Michael Long
West Yorkshire Combined Authority
40-50 Wellington Street
Leeds
LS1 2DE

PLANNING APPLICATION REF: 2020/60/92331/E

Outline planning application for demolition of existing dwellings and development of phased, mixed use scheme comprising residential development (up to 1,354 dwellings), employment development (up to 35 hectares of B1(part a and c), B2, B8 uses), residential institution (C2) development (up to 1 hectare), a local centre (comprising A1/A2/A3/A4/A5/D1/D2 uses), a 2 form entry primary school including early years provision, green space, access and other associated infrastructure

Michael Long
Policy Officer – Planning Coordination

Client:	The Church Commissioners	Job No:	18,006
Project:	Chidswell Masterplan		
Title:	Parameter Plan - Access		
Date:	10/04/19	Scale:	As indicated
Drawing No:	00-205	Drawn By:	BBA1
		Checked by:	RG
		Revision:	E

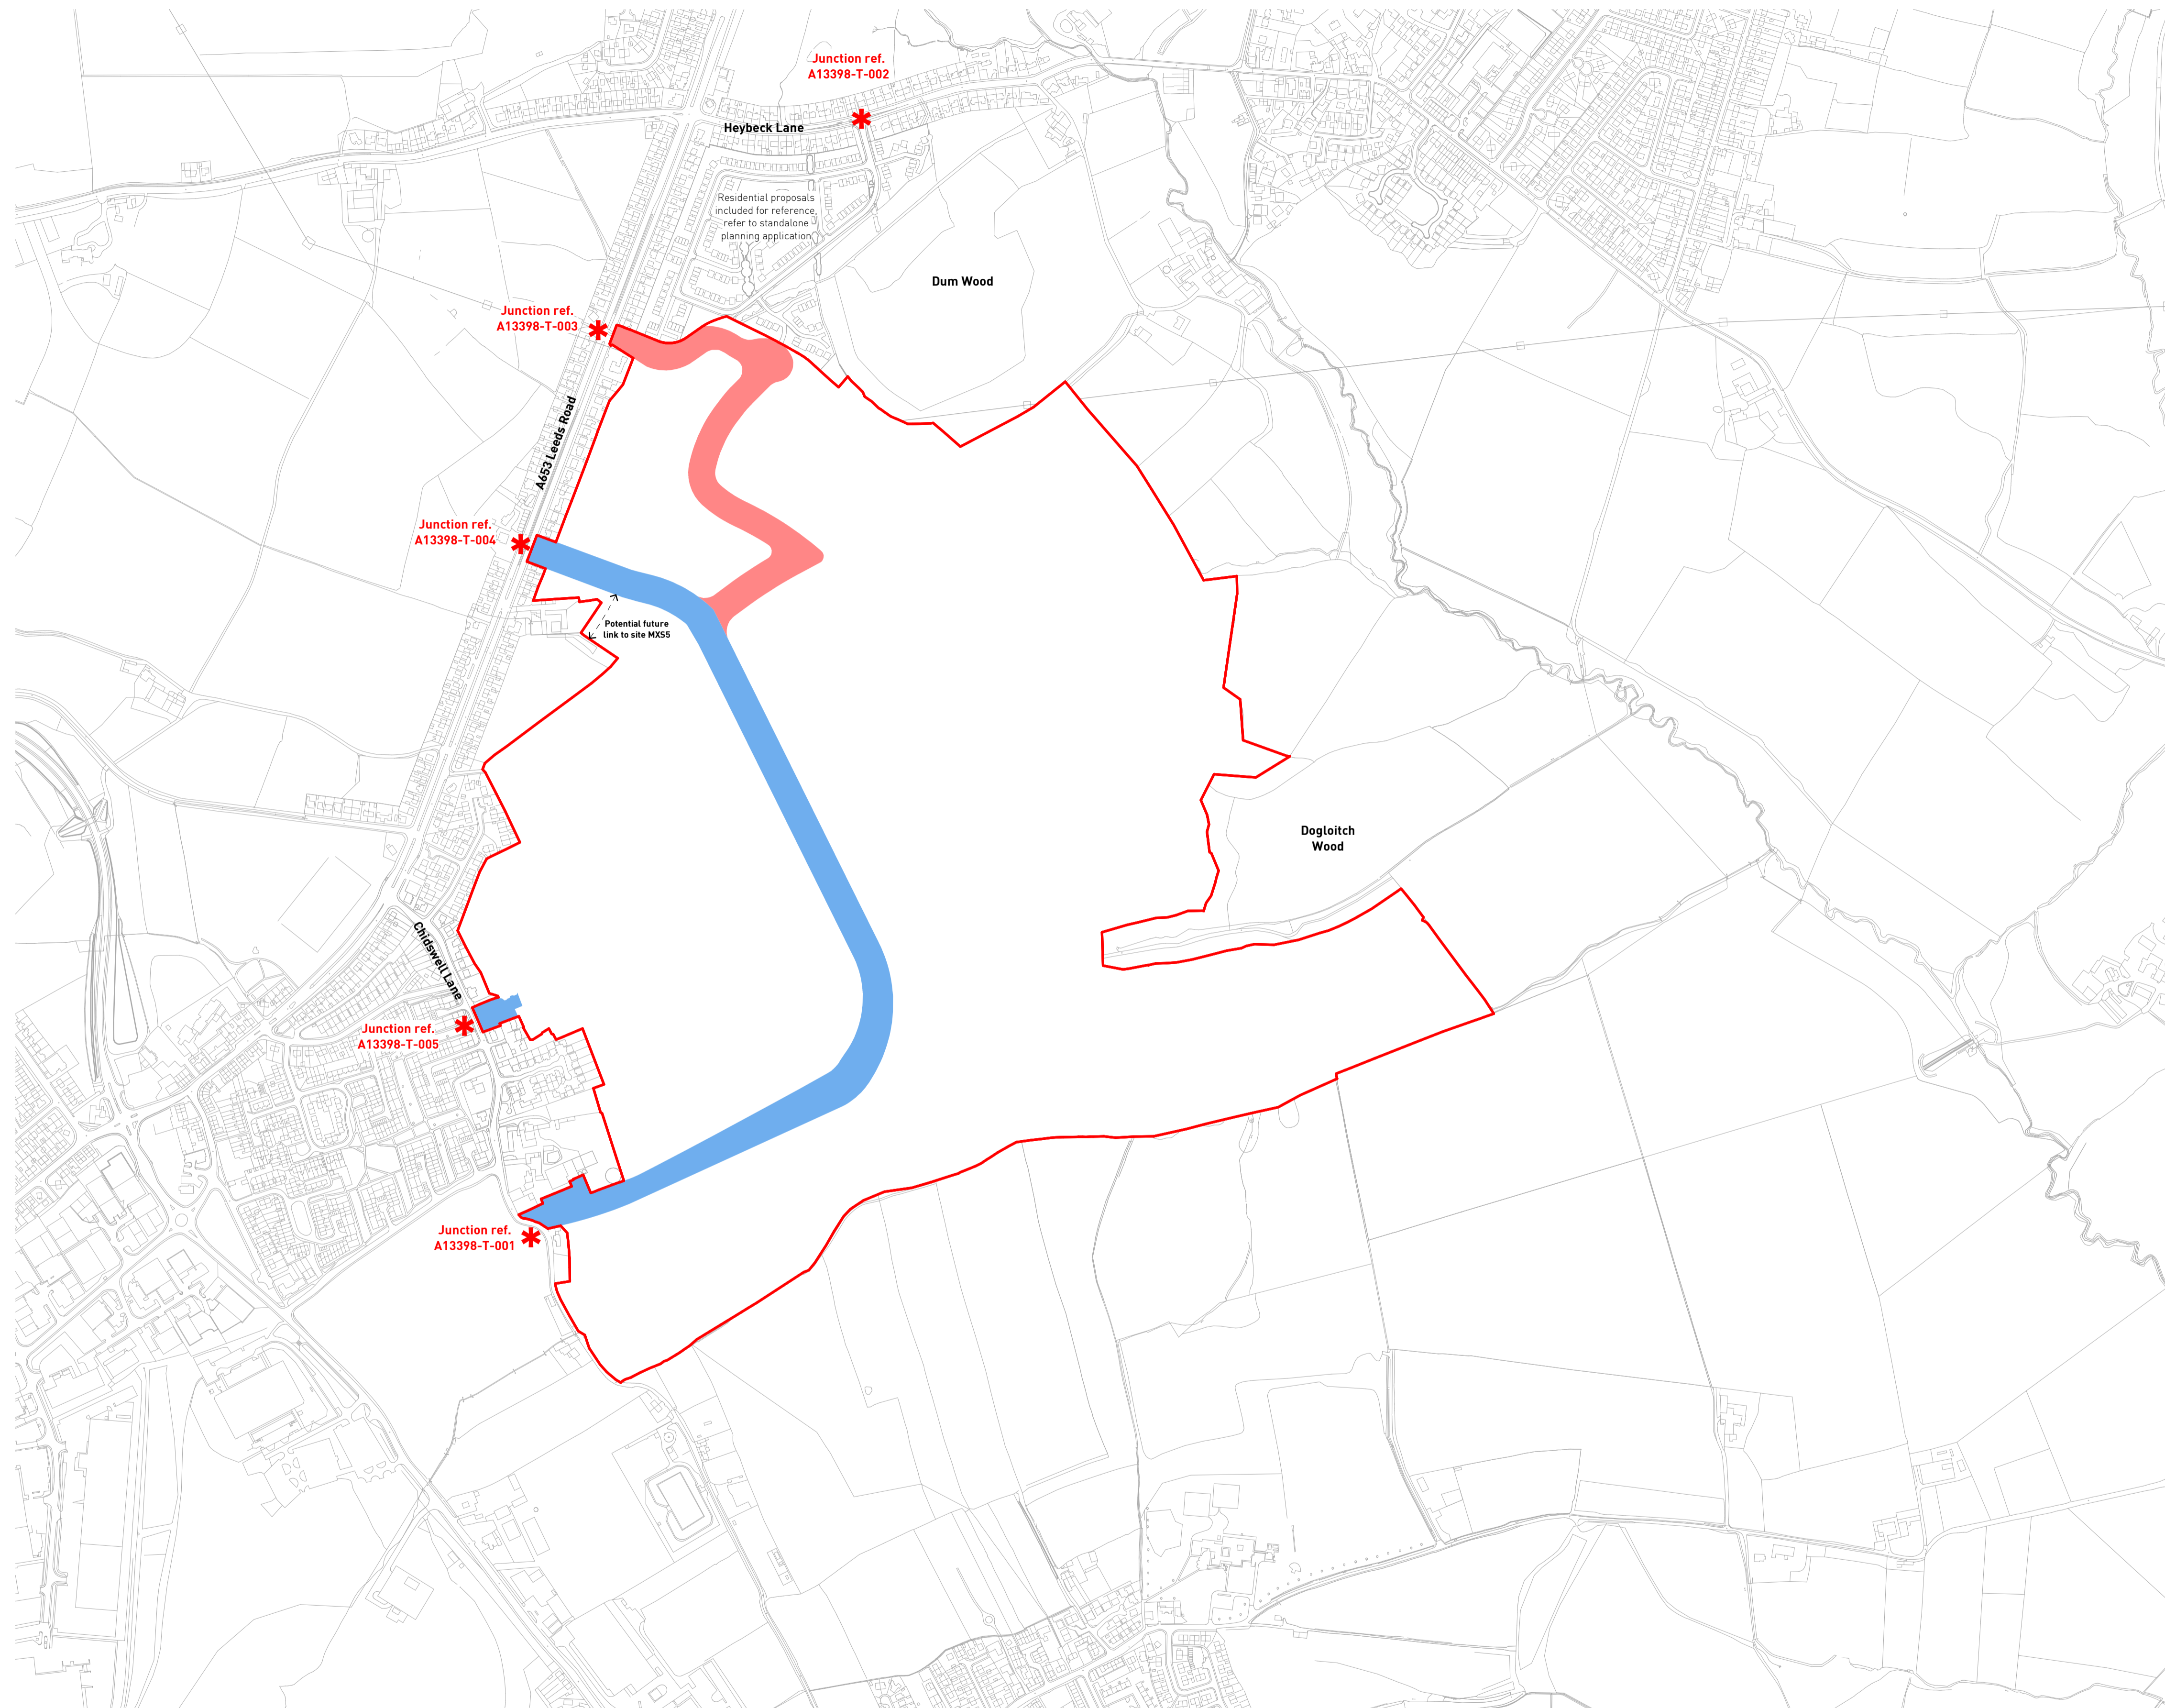
Given the size of the site, it is inevitable that parts of the site will not be within the 400m range of existing bus services. This is acknowledged by the applicant and we welcome the inclusion of the enabling infrastructure to allow buses to access the site. Regarding the access for buses to the site being from point 3 to 5 of the masterplan, has thought been given to buses serving the employment space too as this appears to have been overlooked. Allowing buses through the road marked

'internal vehicular connection' in the masterplan and through access point 2 would be an ideal opportunity to connect jobseekers with employment opportunities by bus.

The drawings are not particularly clear on what infrastructure there would be for buses within the site. The applicant needs to identify where the bus stops planned on the through route will be located and consider bus laybys (particularly relevant near the local centre).
